Subject: 21/00517/F - Land Used For Motorcross, Stratford Road A422, Wroxton

The Landscaping Plan does not address the entire area of application site, not does it provide sufficient detail and reassurance that the site is going to be adequately screened. A chartered landscape architect should be employed to produce the landscape proposals, which are to be justified by the findings of the Landscape and Visual Assessment. I require an addendum to the LVA to justify the reasoning behind the landscape proposals and landscape management plan. How else are we to justify this development?

Figure 1: Map of On-site Habitat Enhancement Proposals

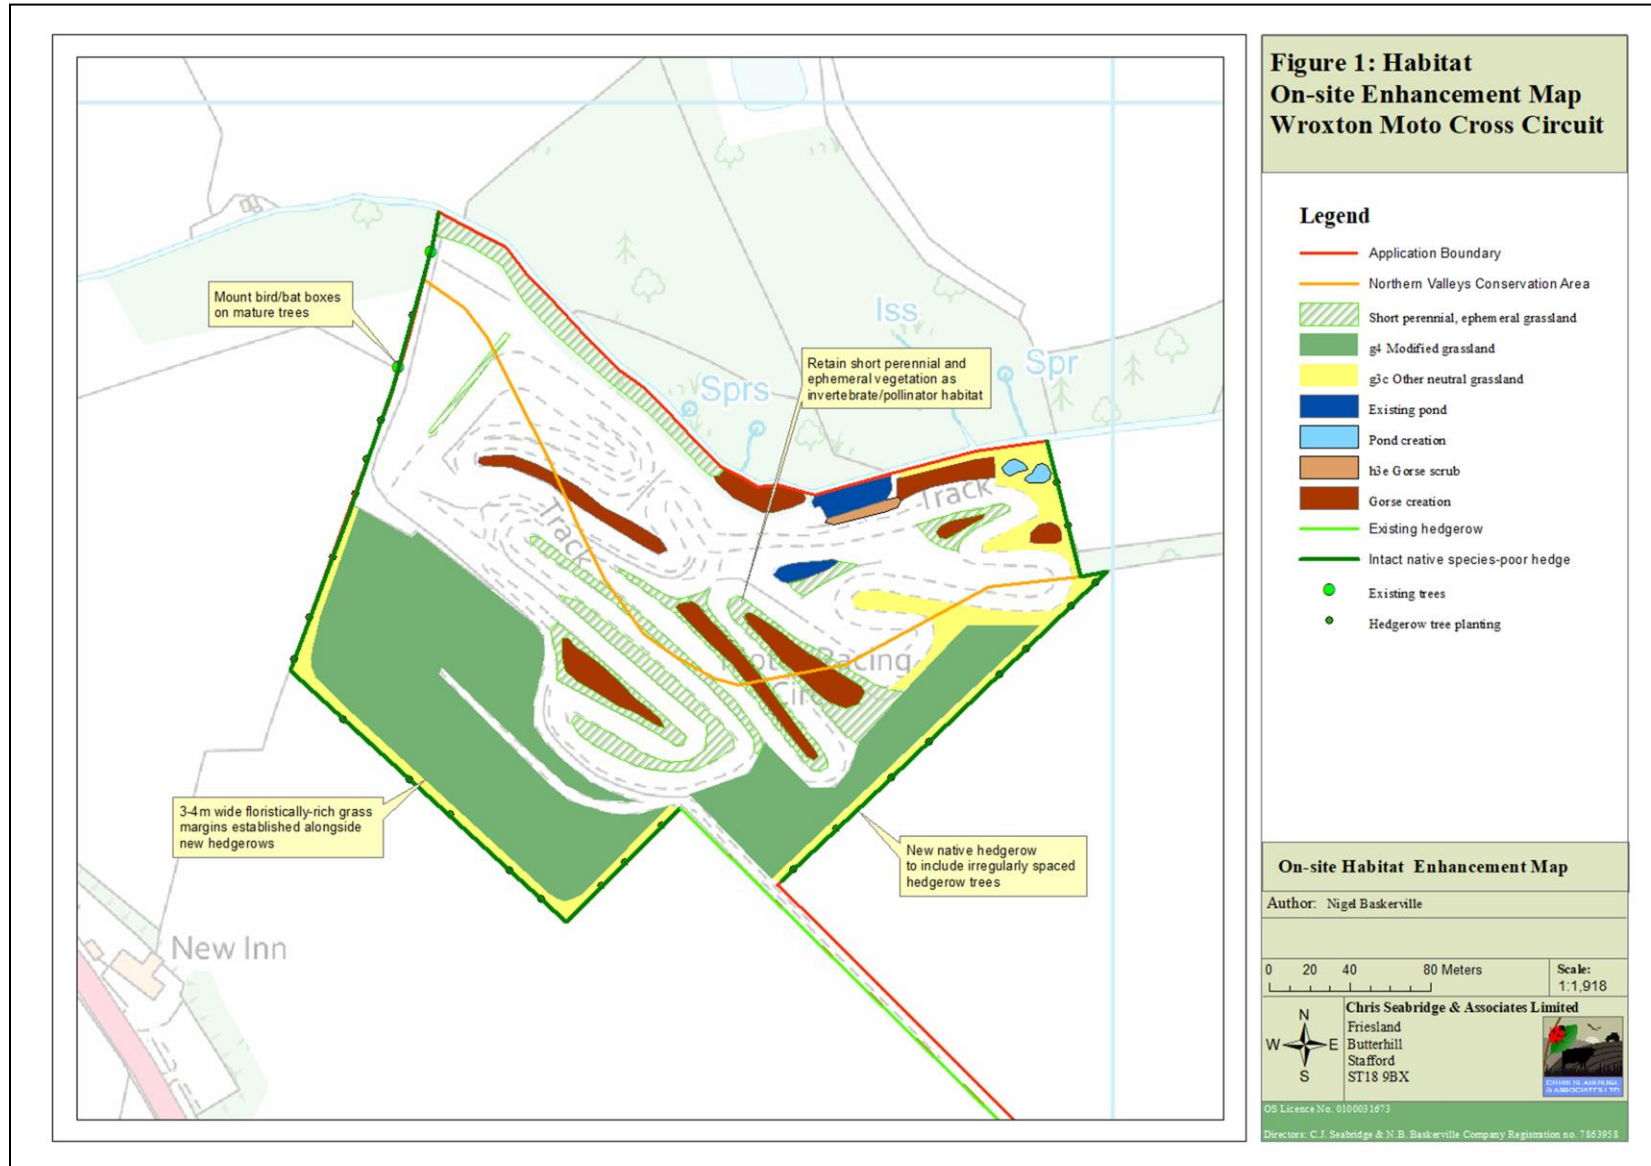
- Species (Latin names)
- Plant schedule with nursery-supplied sizes and planting densities and double-staggered planted hedgerows

- Exact positions/extent of proposed trees, retained trees, woodland and hedgerows.
- Implementation and aftercare proposals in accordance with landscape industry standards
- A separate drawing of tree pit details and tree care in accordance BS8545:2014.
- Proposed 2 m maintenance height of hedgerows above ground.
- Screen planting (trees and retained hedgerow) to the trackway (roadside entrance to site entrance)/busy traffic use on event days.
- All previously agreed ecological recommendations are to be included.

A 10 year landscape management plan is required to ensure the successful establishment of the landscaping, including the offsite habitat enhancement

Figure 2: Map of off-site Habitat Enhancement Proposals

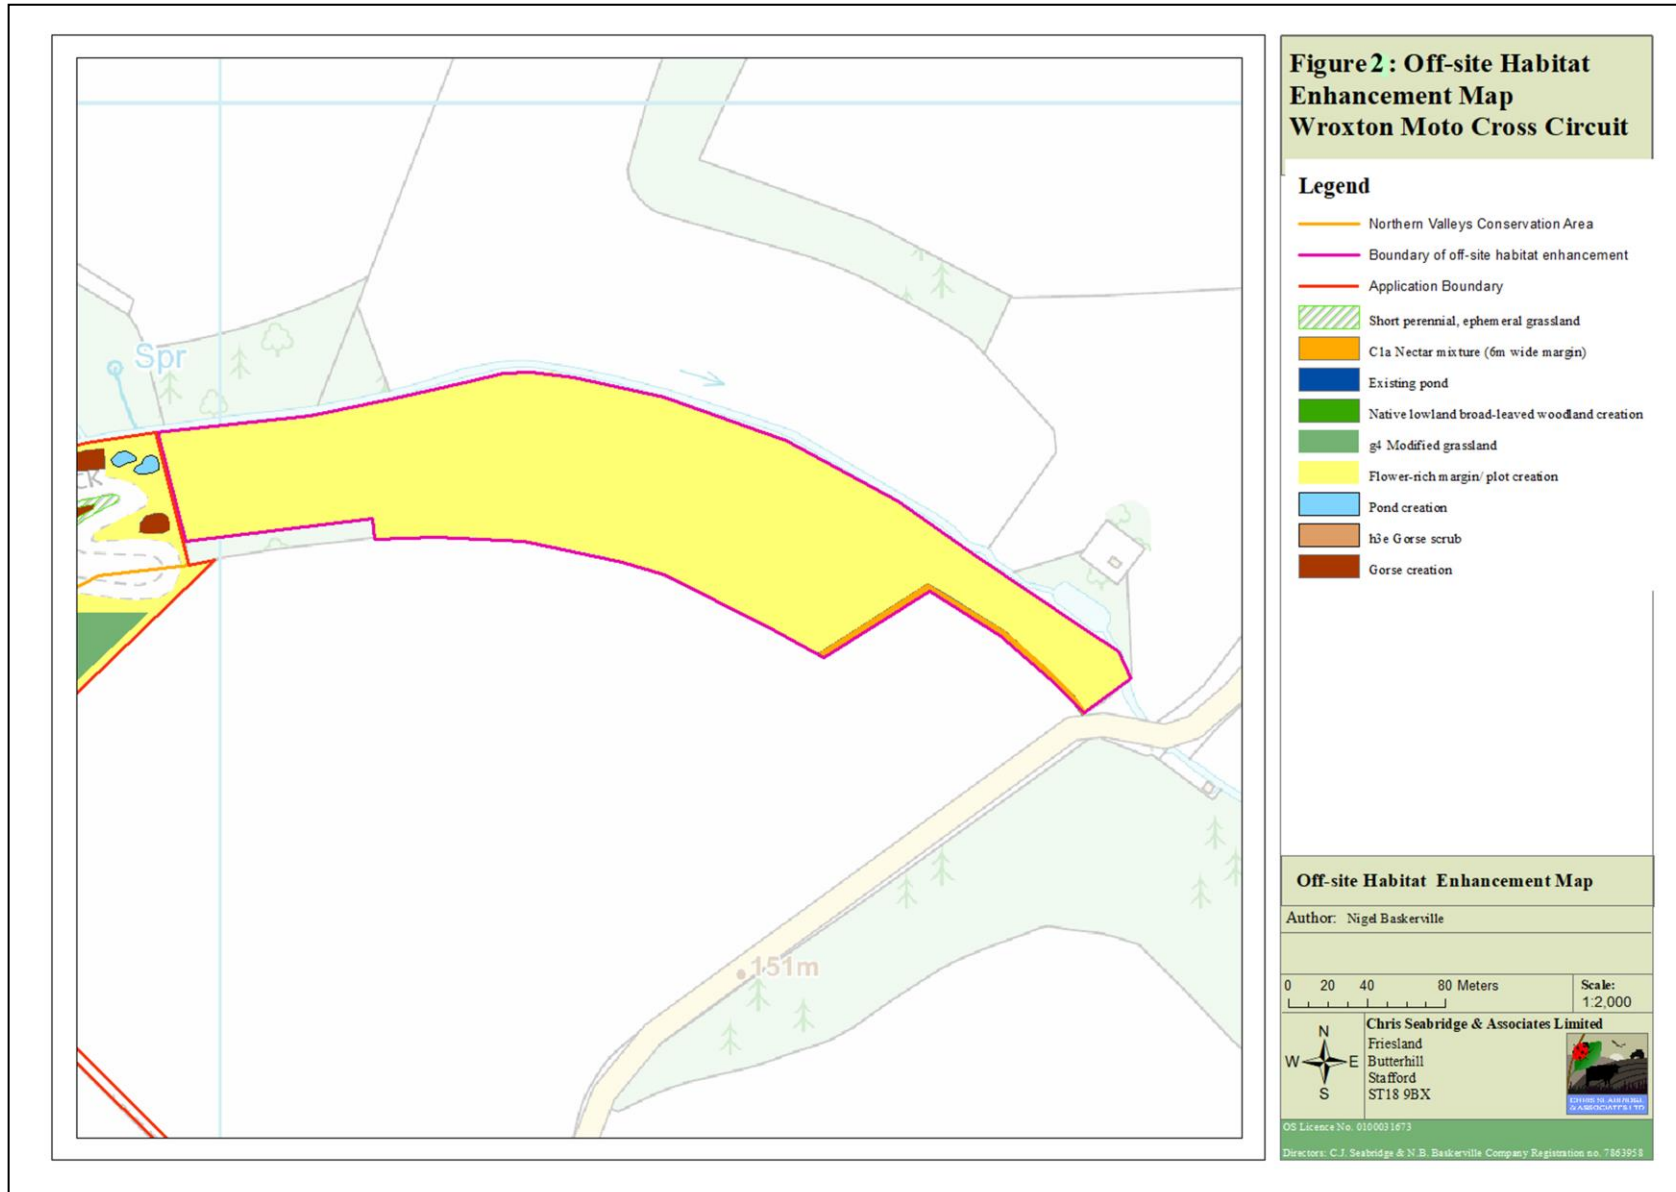
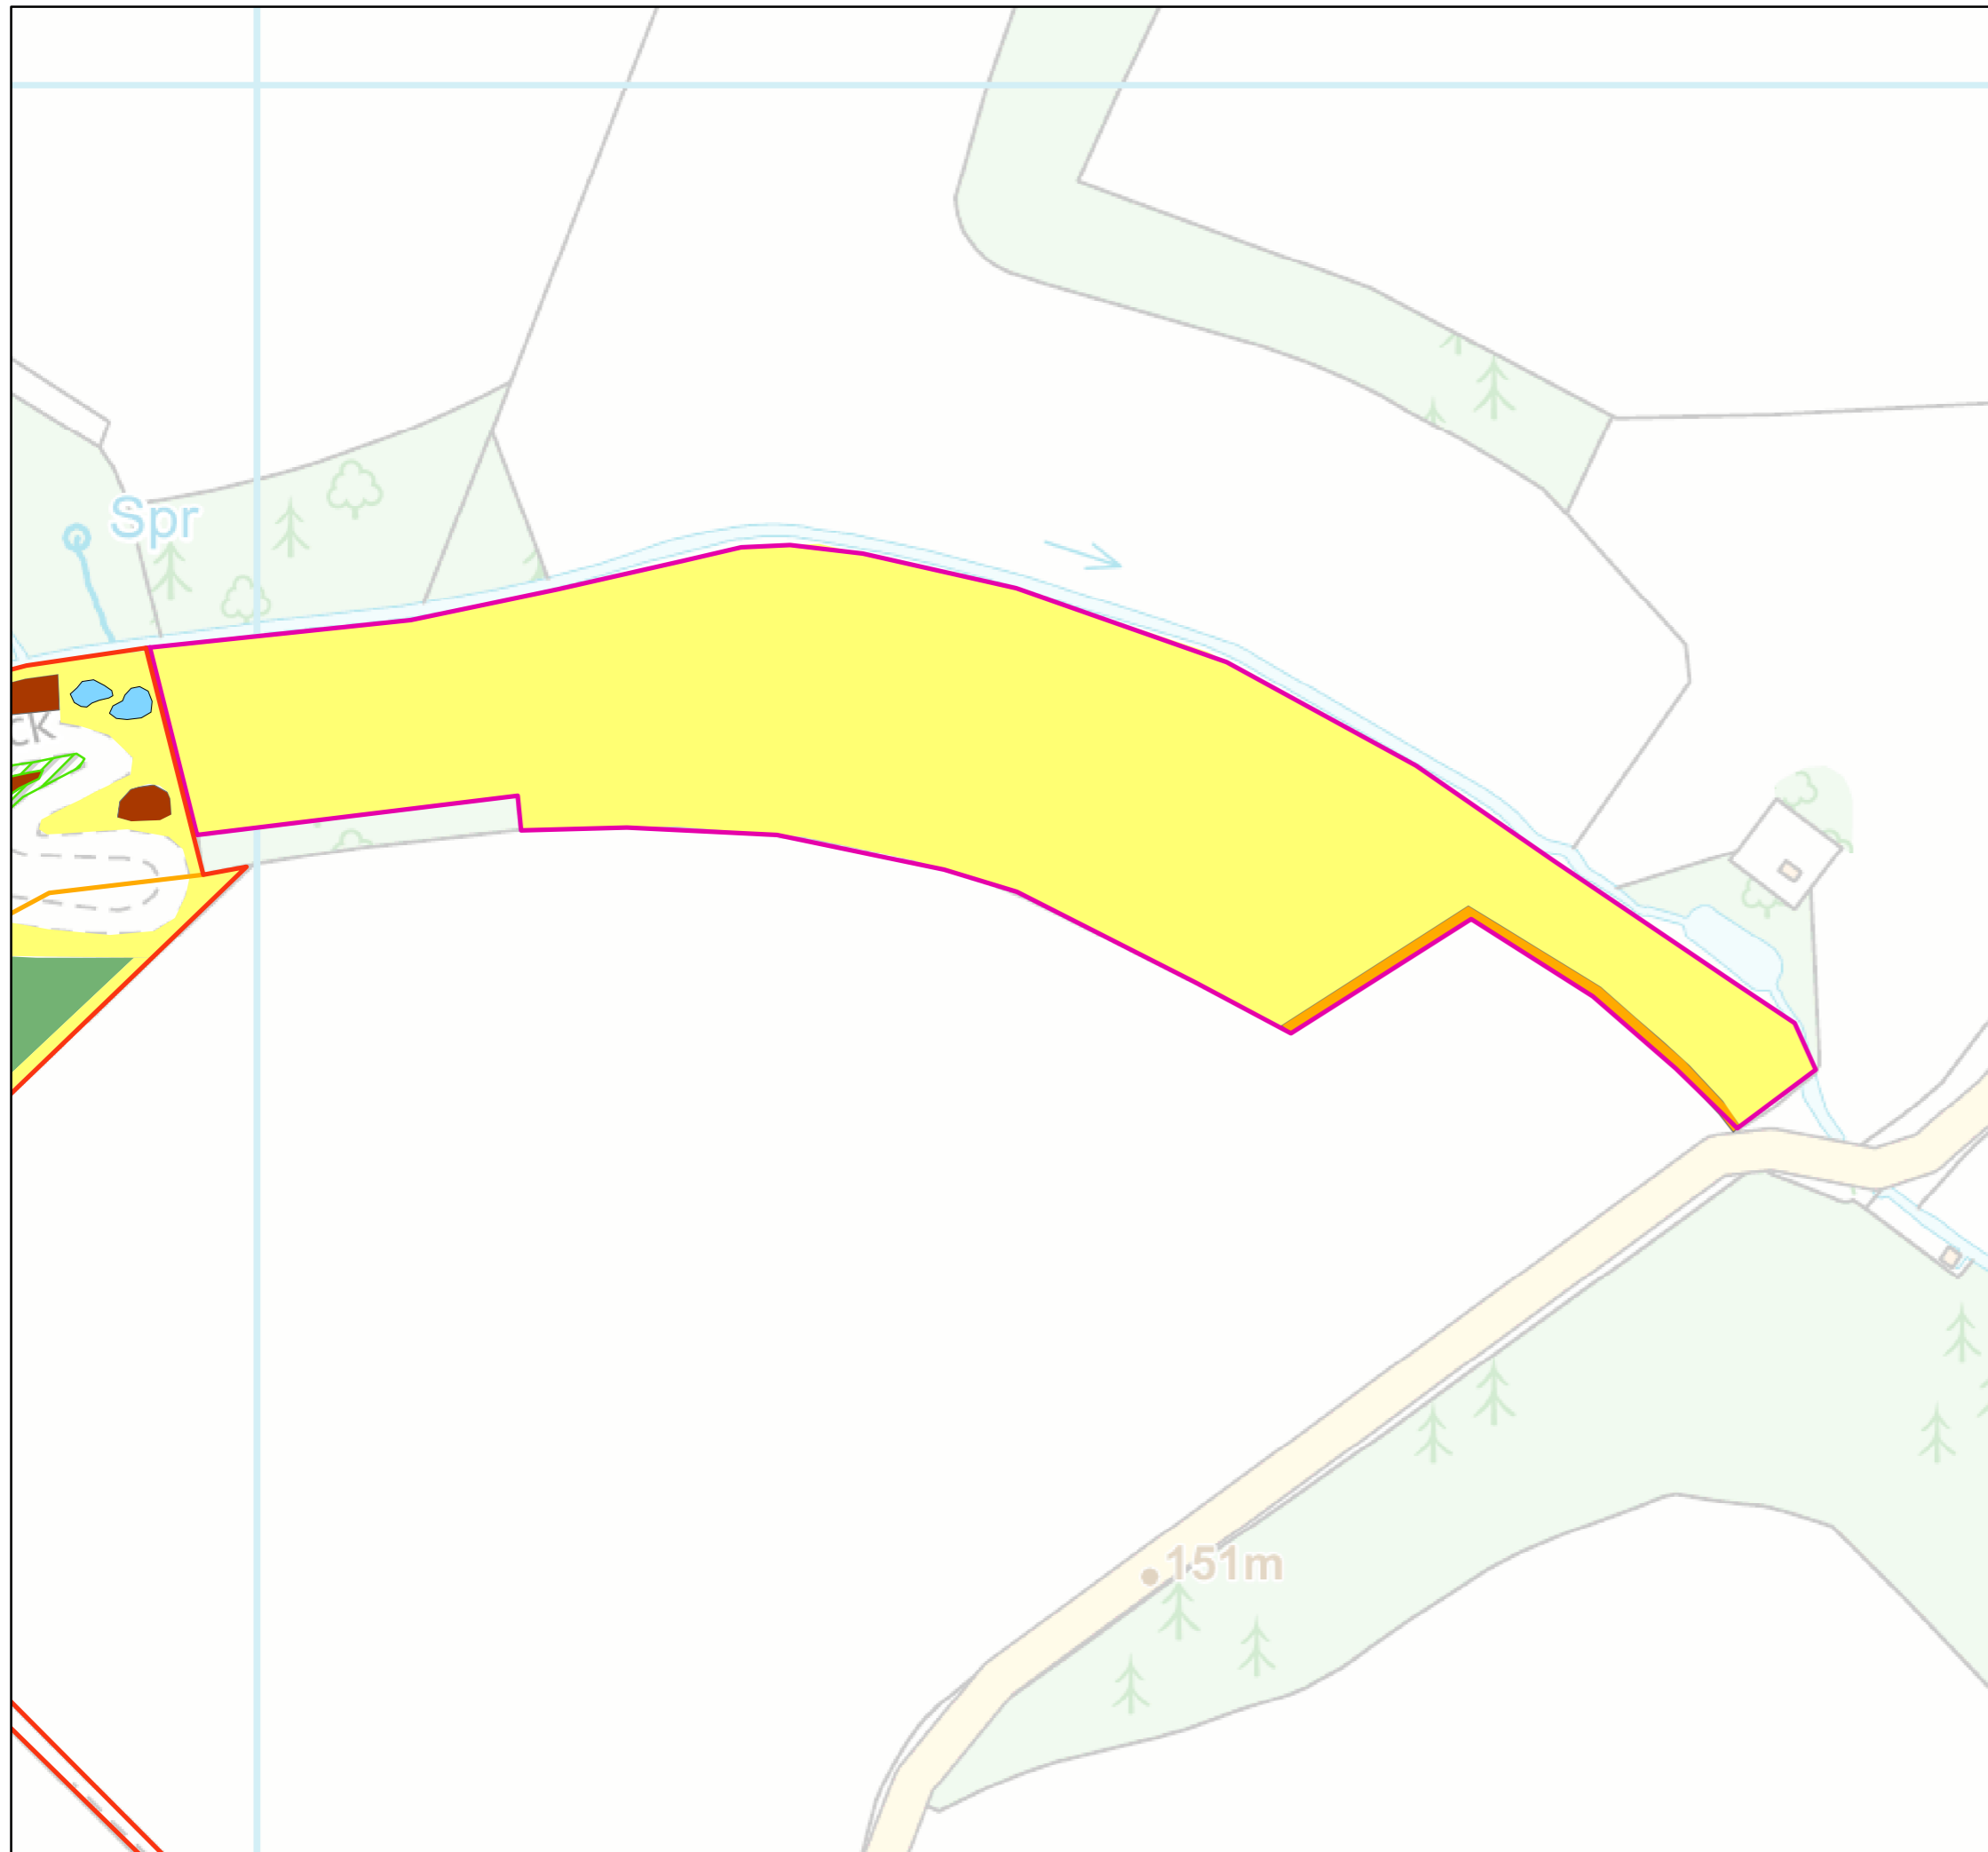
The offsite enhancement plan mentions new woodland, but there appears that the other part of the plan with the woodland is missing from the planning database (please forward) I would look towards extending the off-site woodland belt along the west, south and east application site boundaries for carbon offsetting in relation to the travelling to and from the event and the event itself.
